PROW Planning response 2025/0942 Change of use – TPT Stairfoot car works

Transportation have discussed this proposal with the PROW manager prior to it being submitted for planning consent.

Appendix 5:
Tree Constraints Plan
View 1

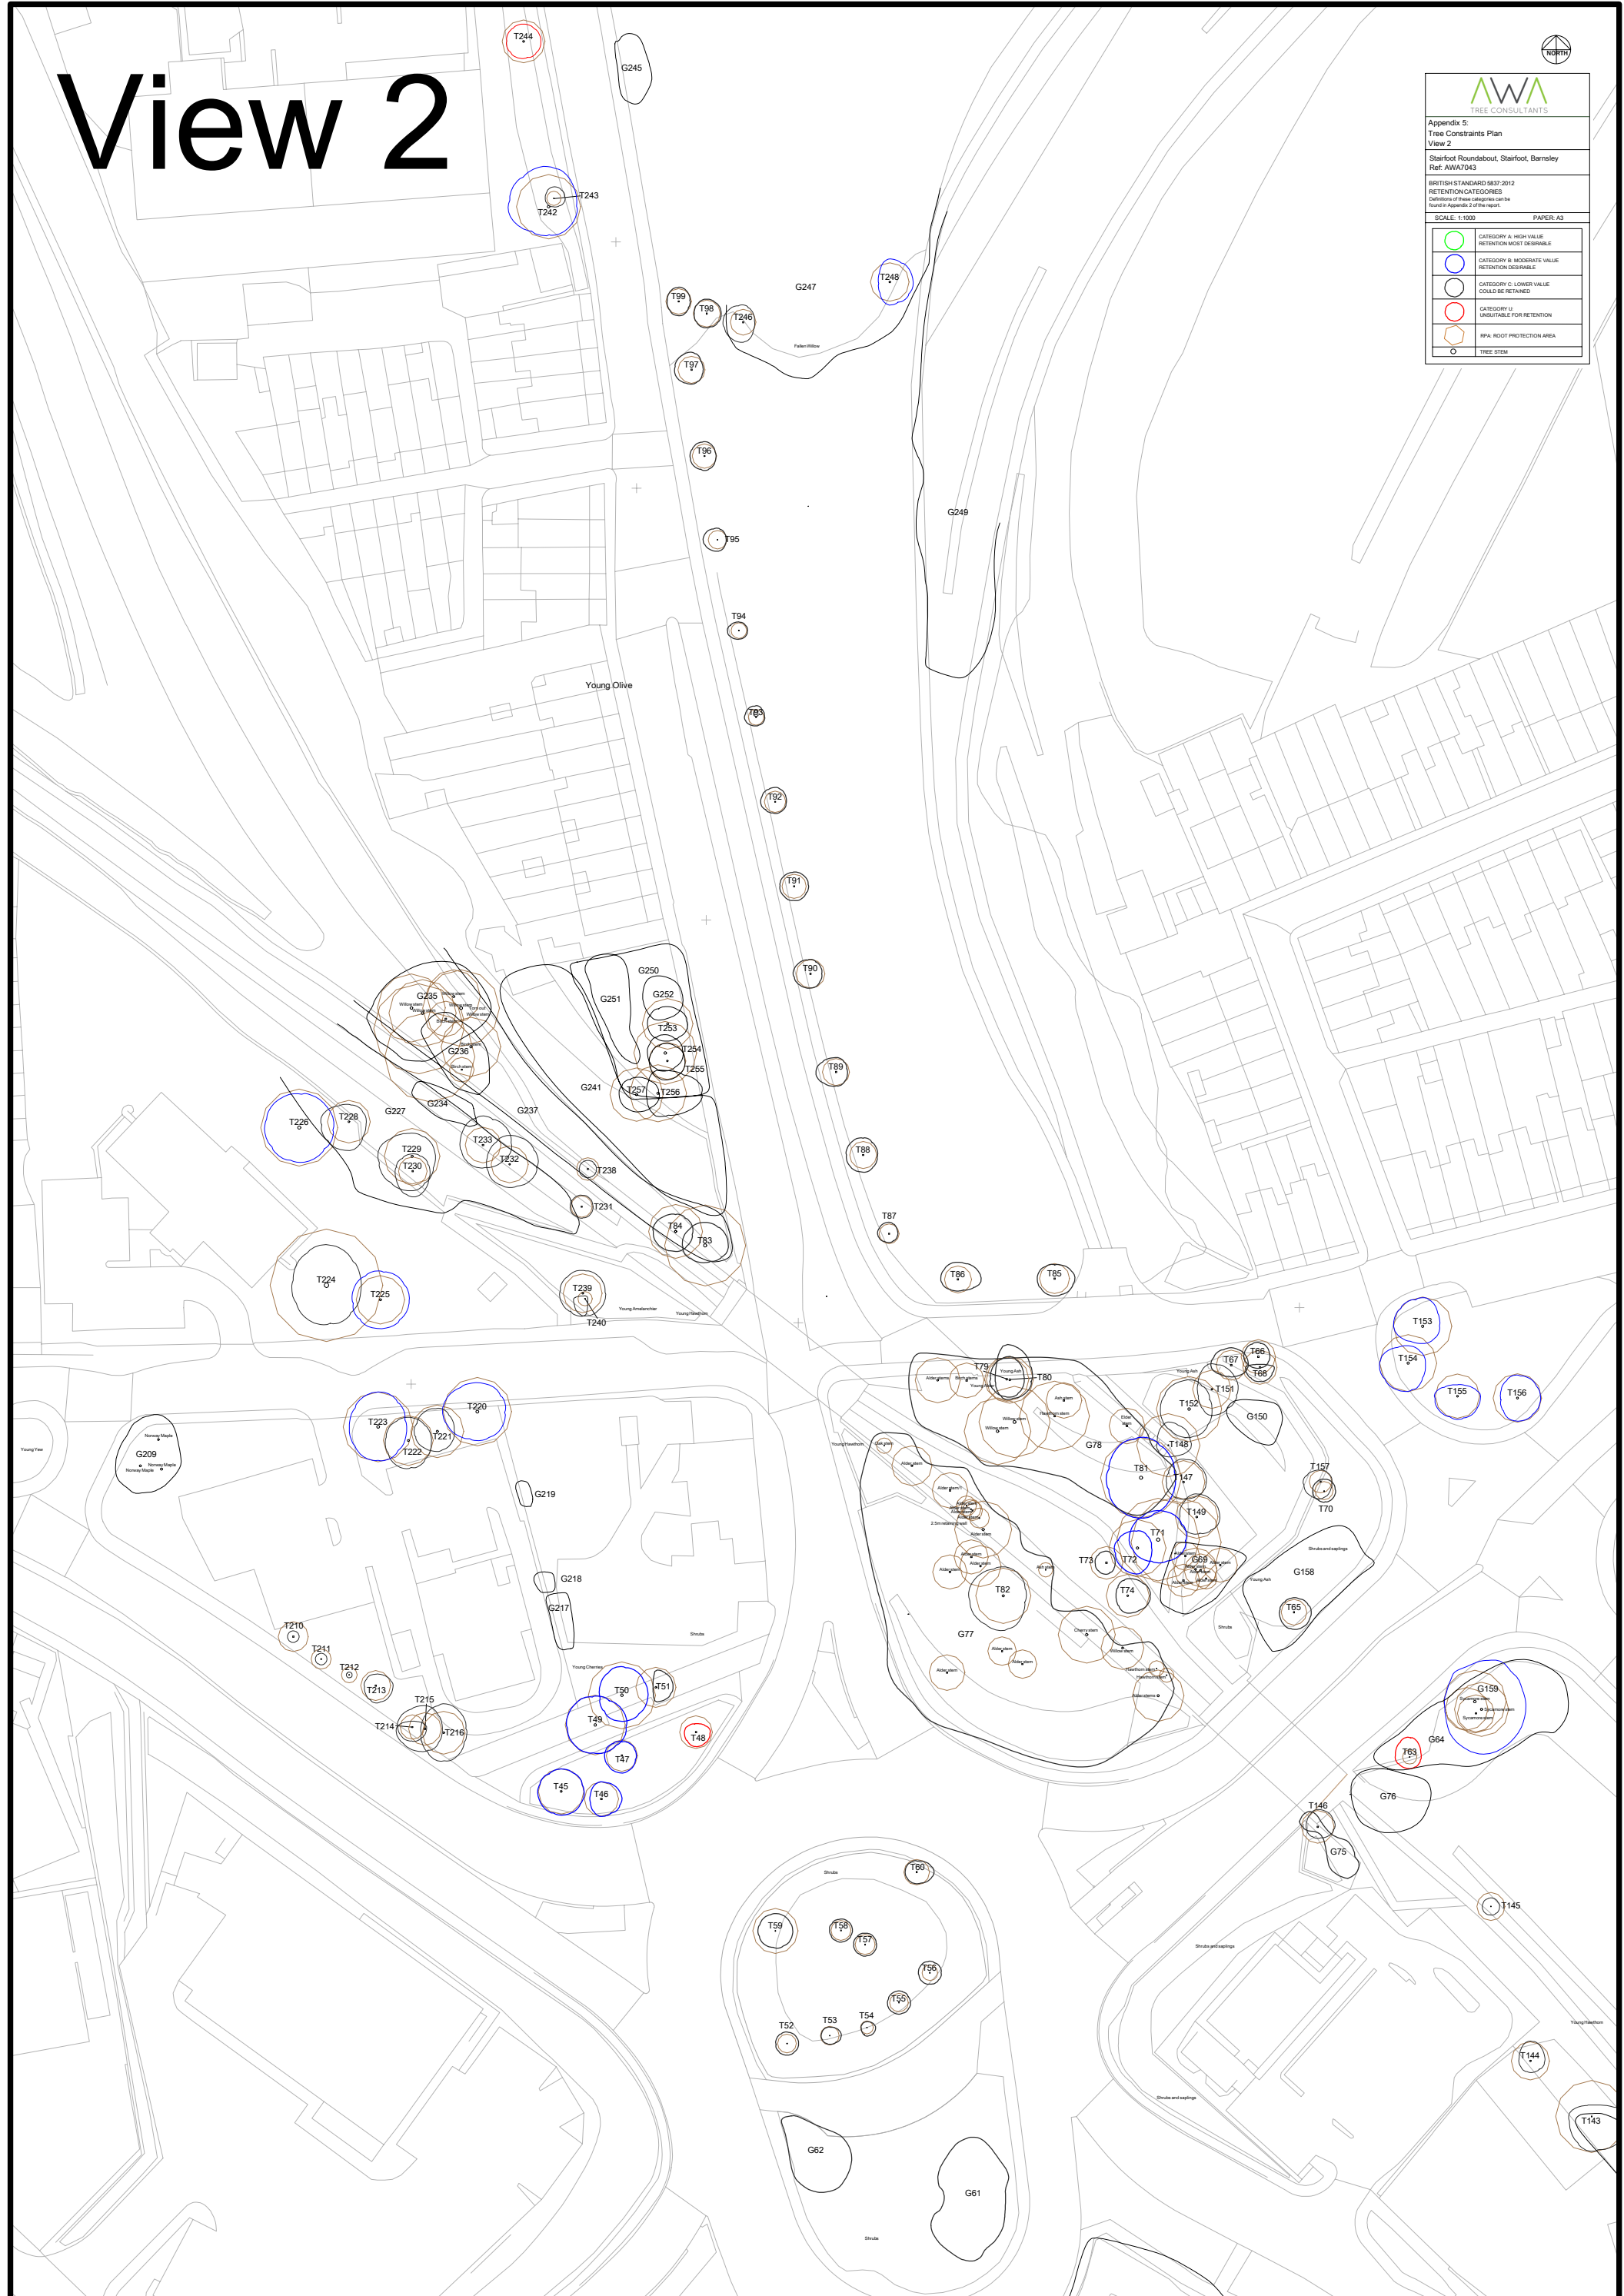
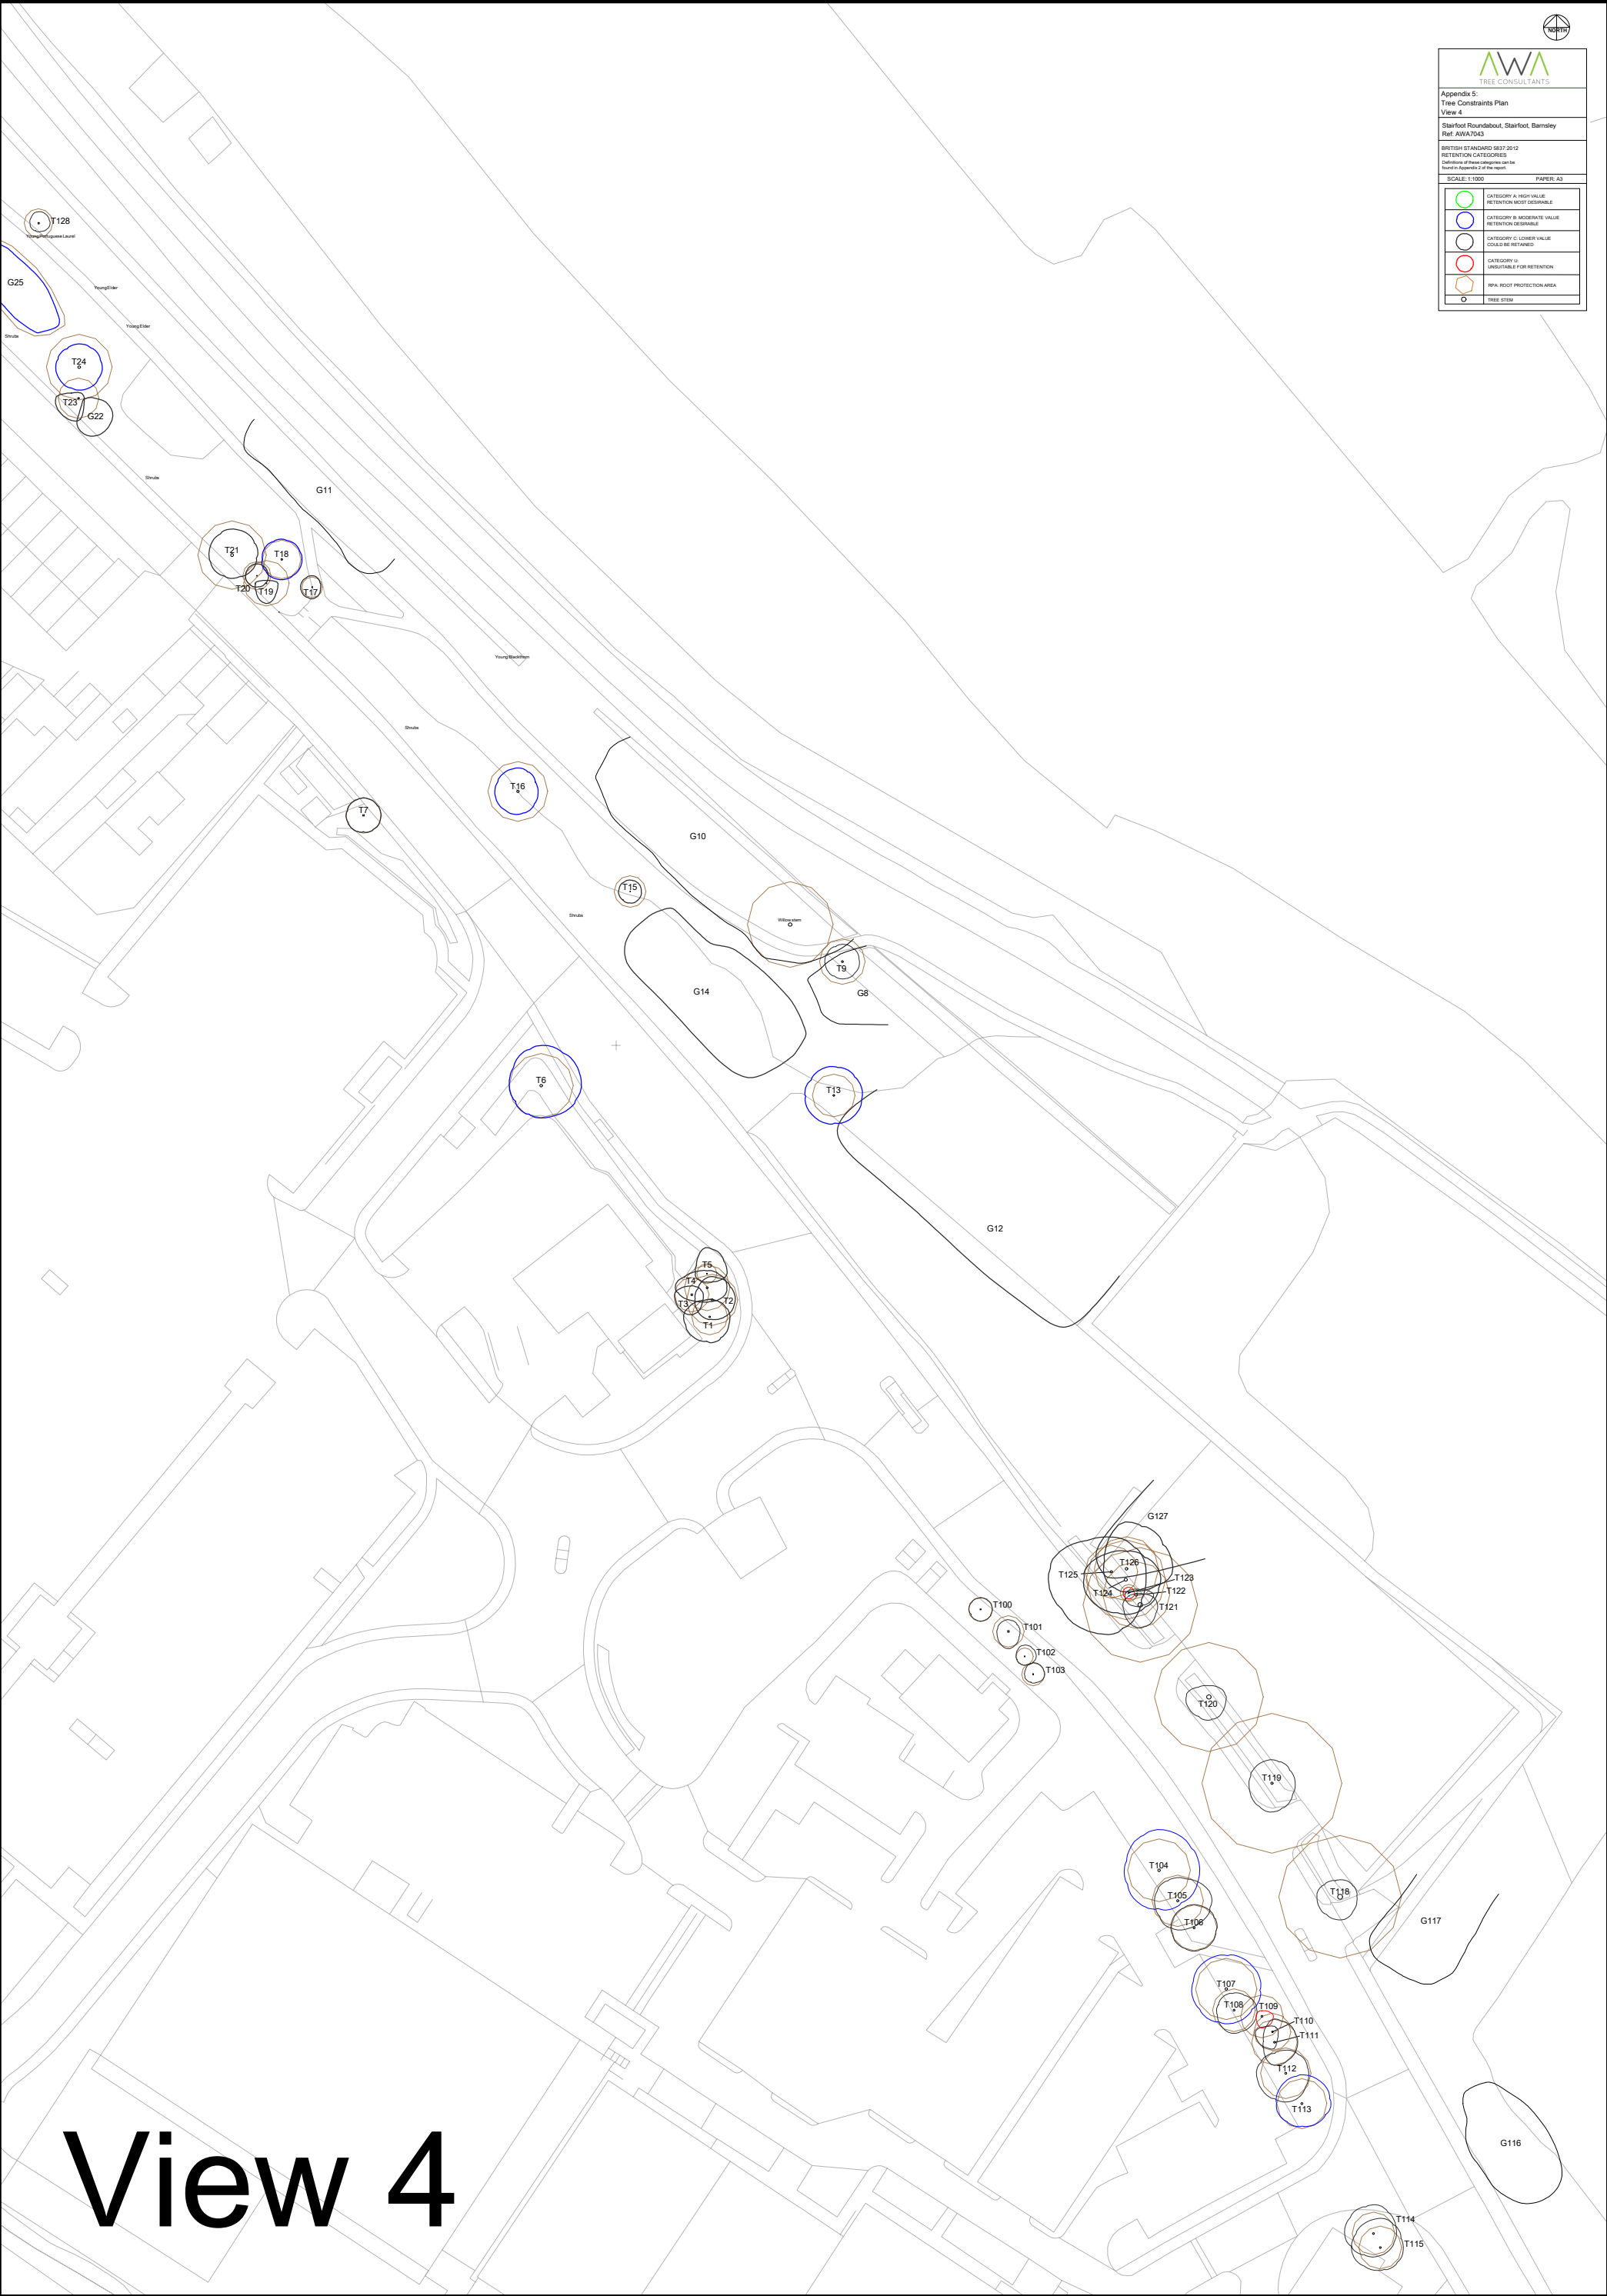
In the preparation for this planning application we asked if cutting back could be considered on the other side of the Trail by the S bends to provide improved sight lines for users coming round the corners. This would be G130 on the Arbo plan (extract below) and would be classed as maintenance of the public highway (which includes bridleways) under our management powers

Looking at the Arbo report there appears to be an error around the corner tree recorded on the extract above as T31. It seems out of number sequence and there is no corresponding line within the spreadsheet for T31. There is a G31 but that is for a group. There is also a T131 on the other side of the Trail already in case there is a number missing.

What ever T31 should be along with T134 and T135 have root protection areas that appear to be within or in very close proximity to the new fenceline. How is that going to be addressed?
